Planning Application Comment

Application Reference : 3/2025/0929

Development Address : 17 Redwood Drive Longridge PR3 3HA

Proposed Site Plan
1:50 Scale

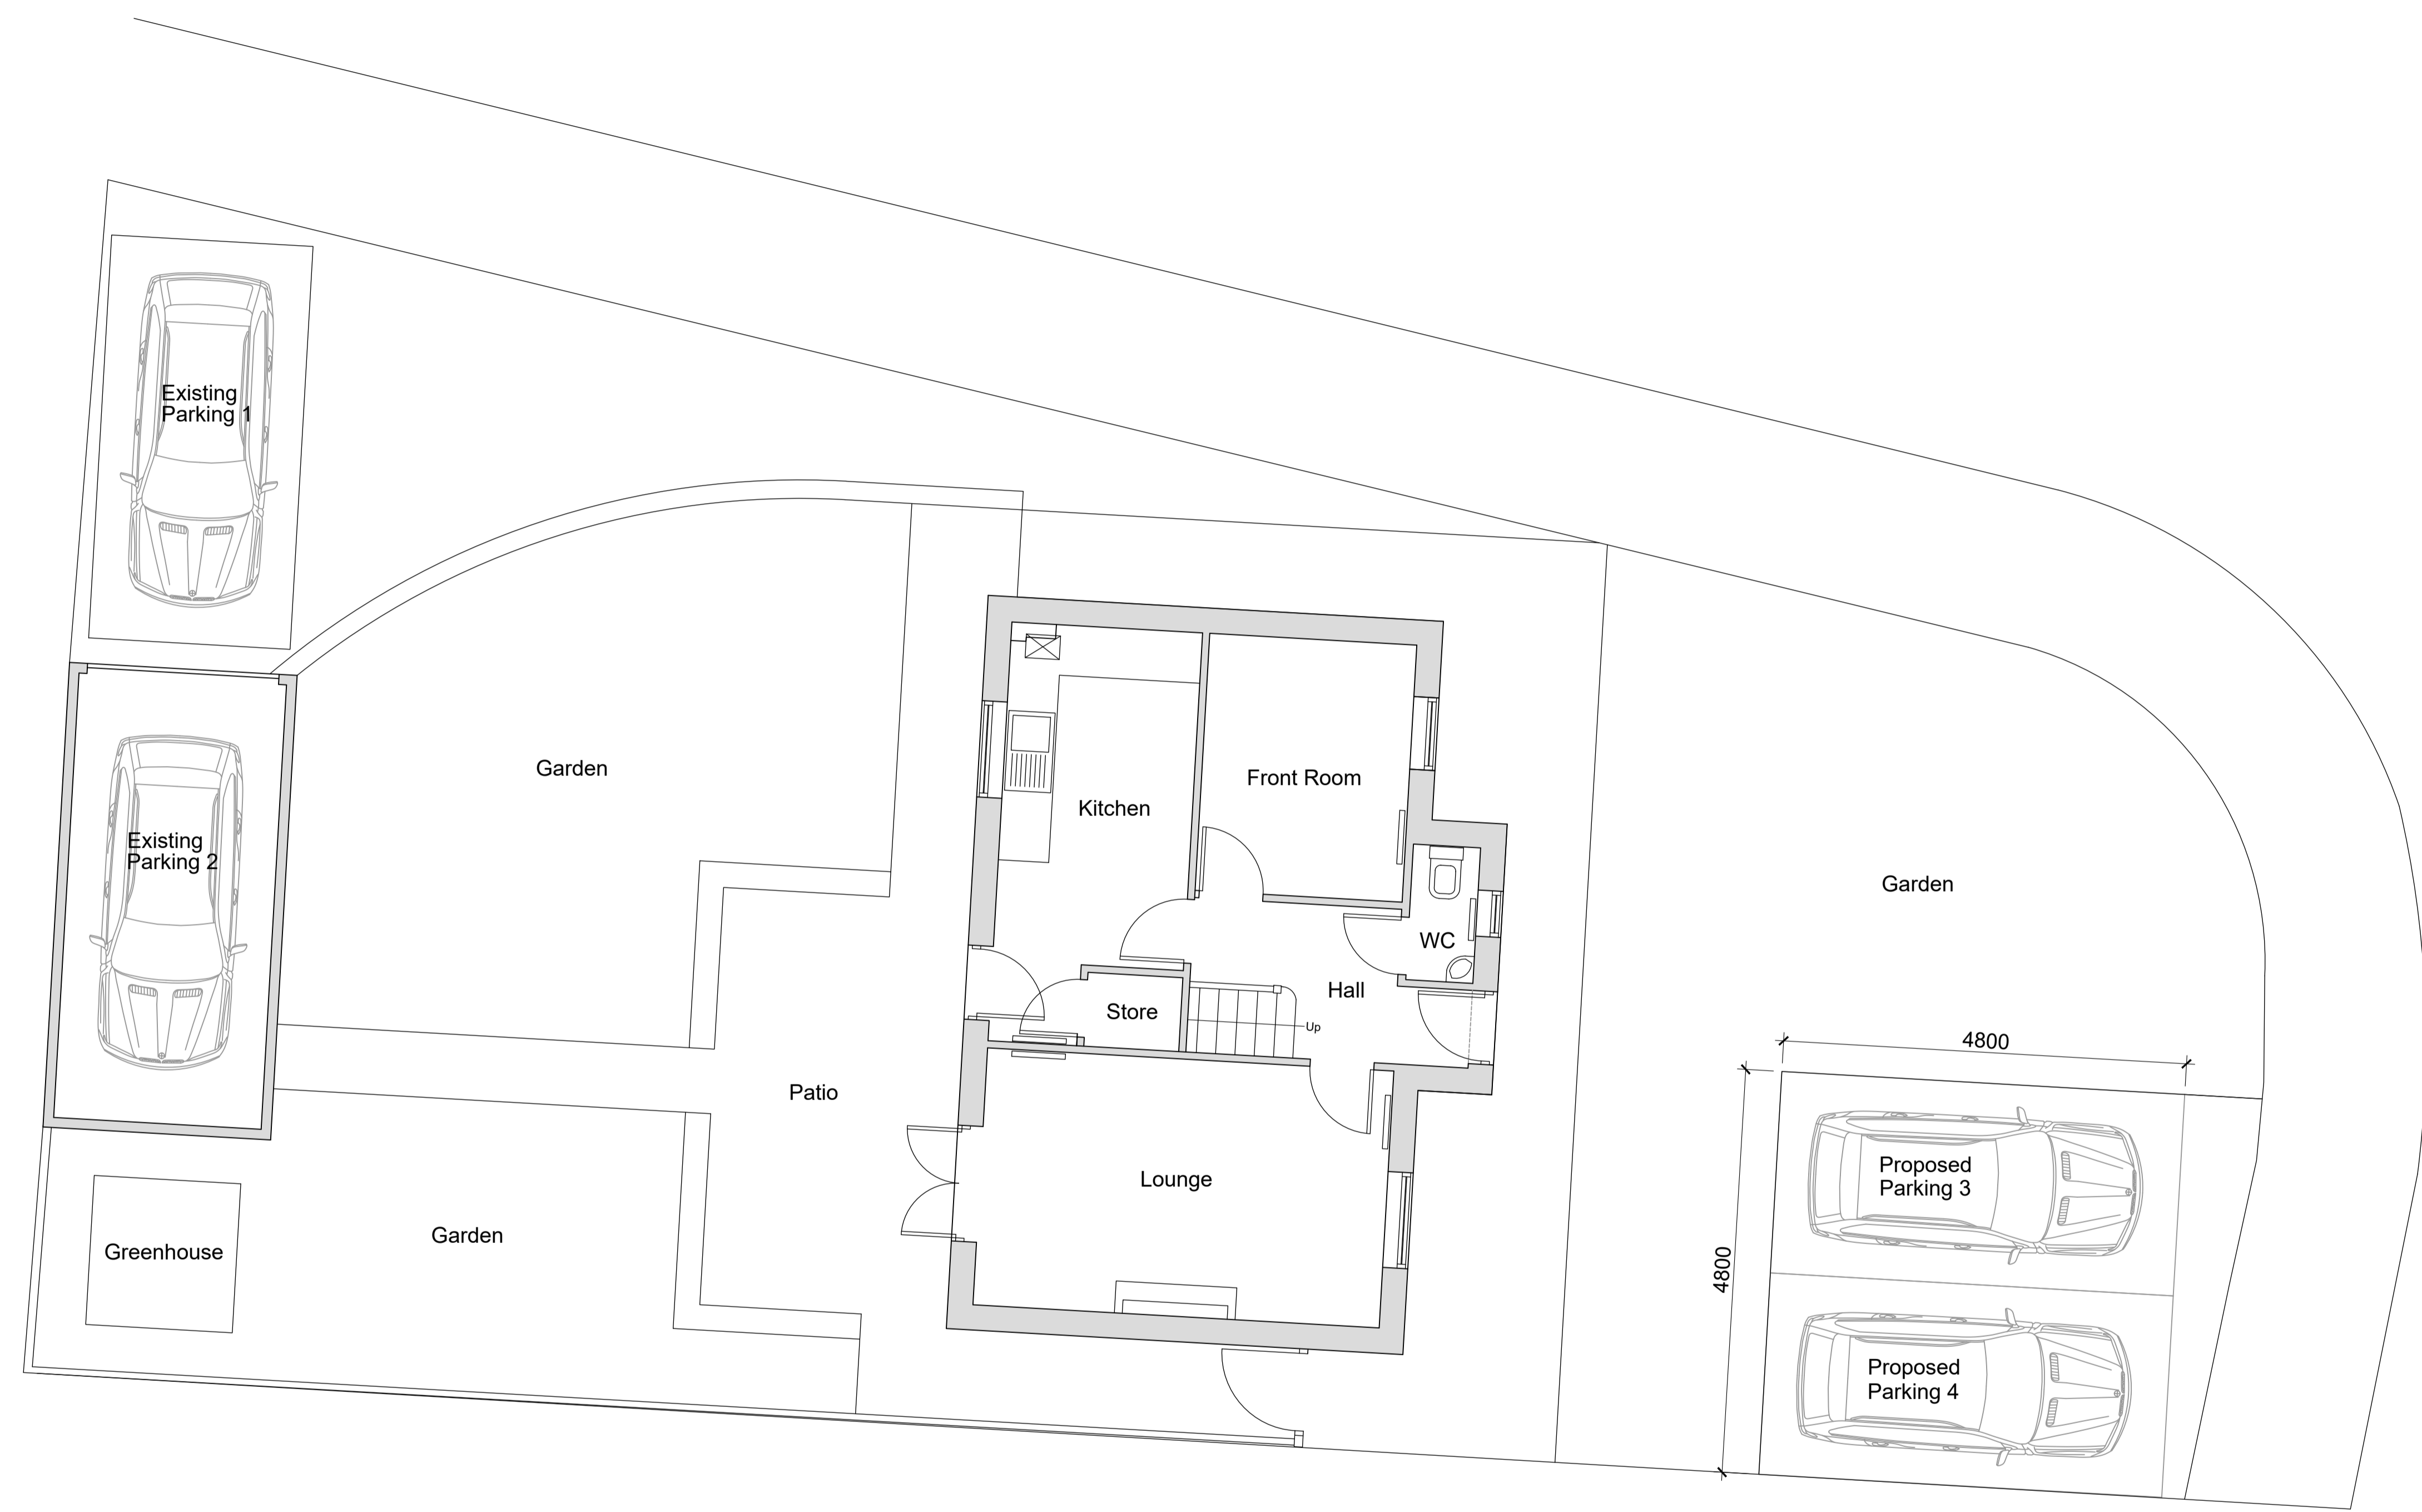
- c) The planning statements sets out “the proposed use would not require any extensions, new driveways, or additional infrastructure”. This is directly contradicted on the associated proposed site plan which shows an additional driveway being installed to the front of the property for two cars. The proposed plan shows a total of 4 parking spaces, which we can only assume the applicant feels necessary to facilitate the proposed use.

This again causes reason for concern that we aren't being told the long-term aspirations for the application site. On street parking in the residential area of Redwood Drive is already, like most streets, problematic. The road currently suffers from haphazard parking on roads which were not geometrically designed with the intention for on street parking. On many occasions the road is blocked to all but small cars. Again, any deviation from the principles set out within the planning statement would surely exacerbate the existing problems. We also note that one of the spaces allocated on the attached plan is within the existing garage. Whilst in principle we agree, human behaviour clearly suggests that staff will not go to the trouble of opening the garage door and using a very tight garage to park their car during their shift, they will simply park on road.
